RE: MP 08_0250 MOD 1 – Modification to Project Application- Hunter Medical Research Institute (Part3AMod)

HMRI Responses to Newcastle City Council comments 3 to 8 for consideration by the NSW Department of Planning and Environment – Modification Assessments.

Fig 1: Original Plan of Subdivision Document Ref CRH12-354C_DP_2A.pdf. This extract from the plan of subdivision whilst not appended to the NCC comments, has been included to aid in understanding of the ZHMRI response to the comment.

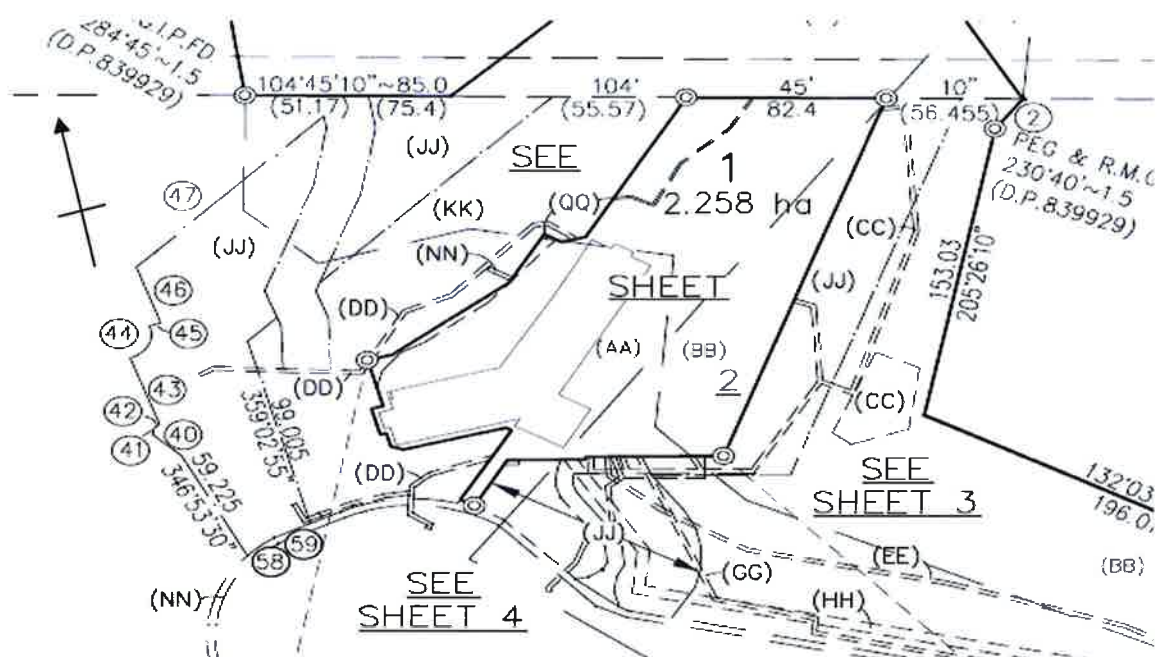
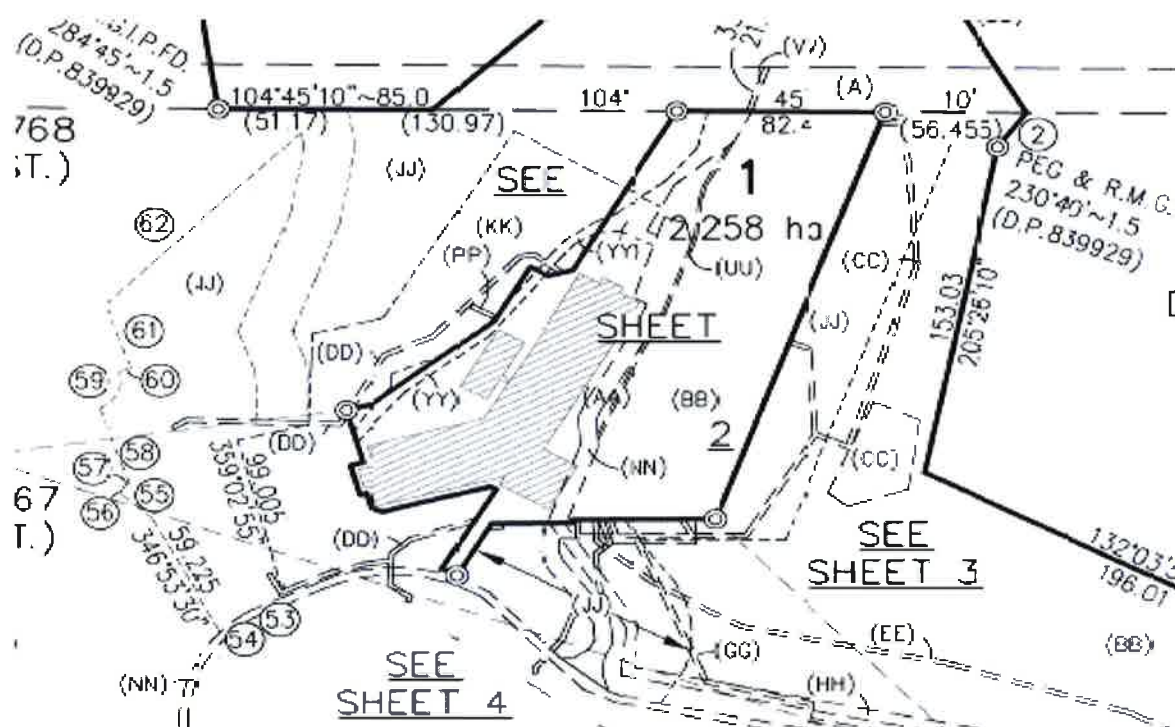
Comment 5 – That part of the land shown burdened by easement (JJ) Outer Protection Zone to the east of proposed Lot 1 should be notated as (KK) Inner Protection Zone is ^(sic) to comply with the Statement of Commitment 7.4 Bushfire – Recommendation 2 (See Appendix B of the Project Approval)

HMRI Response – Agreed. As previously discussed per comment 3, this is an error which the Surveyor has agreed to correct before resubmitting the revised plans of subdivision.

Fig 6. Conditions of Consent Drawing K1002 - key Drawing Access & Movement Pedestrian & Bicycle Movement

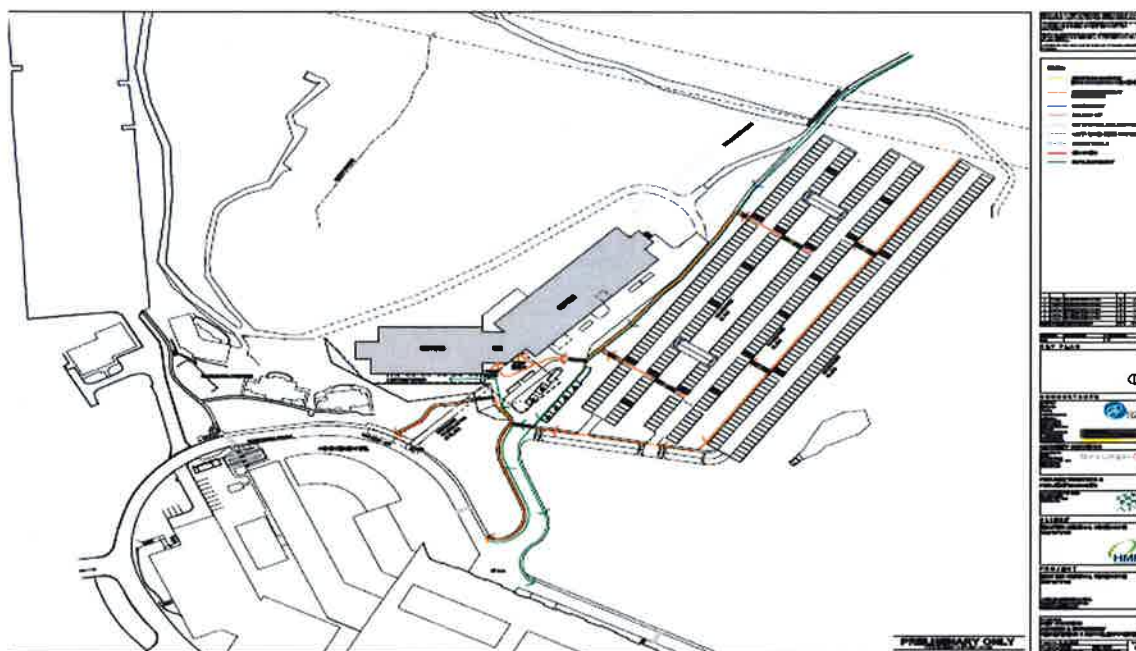
Comment 8 – The shared pathway entering proposed Lot 1 from the bushland to the North appears to be at least 2.5m wide, however proposed Easement (QQ) is noted as a Right of Footway 1m wide and variable. It is also apparent from arial photographs that the shared path provision extends further south than as depicted in the draft DP. The easement should be amended wholly to contain this pathway. Consideration should also be given as to who is to have benefit of this easement as members of the public might use this pathway to access the wider HNEH campus.

HMRI Comment – Agreed. NSW Government Department of Planning Document Ref : Determination of the Hunter Medical Research Institute Project – Major Project No. 08_0250, Schedule 2, Part A – Administrative Conditions Clause A2 states that “.. The Proponent shall carry out the project generally in accordance with the following plans documentation and recommendations ...” made therein:

Section (d) of the table referencing the aforementioned statement identifies a list of Architectural drawings which are to comply with the statement. Drawing K1002, Revision 5 Titled “Key Drawing Access & Movement Pedestrian & Bicycle Movement” dated 7/08/2009 and appended here below as Fig. 6, clearly supports a view that it was the intention of the Department when approving the development that there would be a direct linkage between the existing Jesmond shared bike and pedestrian Track and a path of travel through the HMRI site (see the green shaded flow through the drawing).

In Summary – We agree that there is a clear requirement to have a connected cycleway through the HMRI site and that this was always the intent of the conditions of consent. We propose that we will survey both the pedestrian path and the pushbike cycleway and provide easements for both in accord with the original intent of the Drawing K1002.
